HIGHWAY REPORT ON PROPOSALS FOR DEVELOPMENT

DISTRICT:	Bassetlaw	Date received	19/04/2023
OFFICER:	Amanda Broadhead		
PROPOSAL:	Erect Stables on Existing Grazing Land	D.C. No.	B/23/00232/FUL
LOCATION:	Land Adjacent To A161 And Oil Wells Holes Beckingham Road Beckingham DN10 4 QD		
APPLICANT:	Mr Leeroy Lee

TITLE	PROPOSED STABLES / PADDOCKS	
LOCATION	LAND OFF A161 BUCKINGHAM RD.	
CLIENT	MR. L. LEE	
SCALE	DATE	DRG. NO.
1:100	FEB '23	MW/LL-01

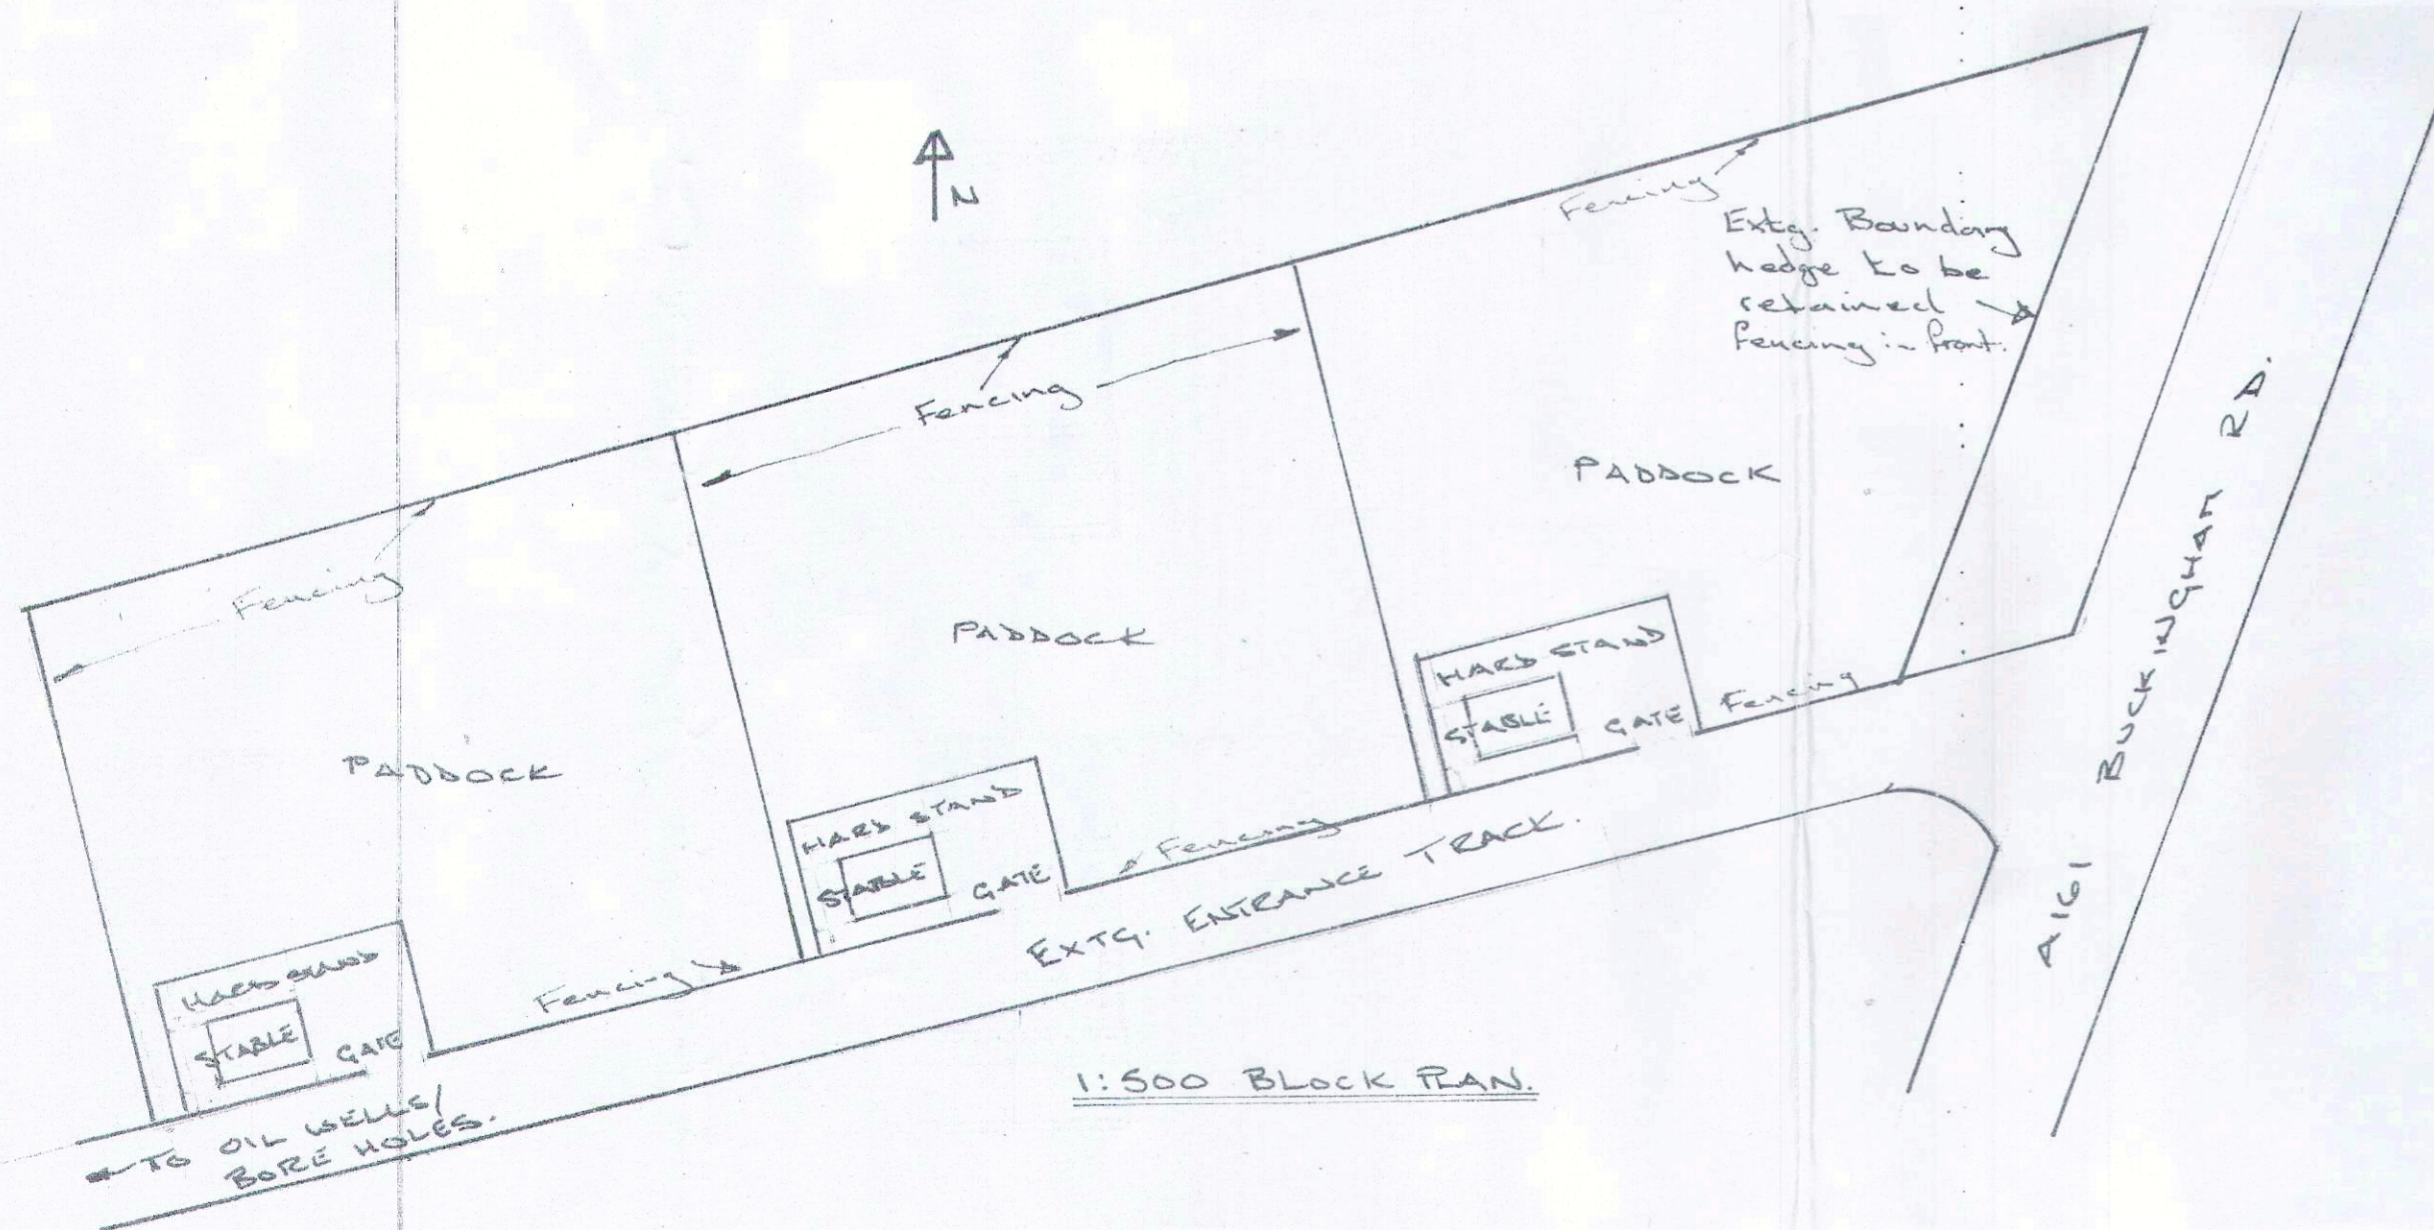
The Highway Authority currently has concerns about the existing access onto the A161. Therefore, the applicant should provide plans to demonstrate the following:

- That an adequate level of visibility can be achieved from the access onto the A161 from a 2.4m 'x' distance, taking into account existing vegetation and signage / structures / equipment within the public highway. Further guidance on measuring visibility splays is available in part 3.3 of the Nottinghamshire Highway Design Guide (www.nottinghamshire.gov.uk/transport/roads/highway-design-guide).
- That the access is of an adequate width to permit unrestricted 2-way traffic flows by horse boxes / vehicles towing horse trailers onto and off the A161. This should be demonstrated by vehicle tracking.

The applicant should ensure that no part of the proposed development encroaches into the public highway. For the avoidance of doubt, a plan defining the extent of the public highway can be obtained from this Authority's Highway Assets team (highwaysearches@viaem.co.uk). There may be a fee associated with this service.

At this time, the applicant has not demonstrated that the proposal will not affect safety on the all-purpose highway network.
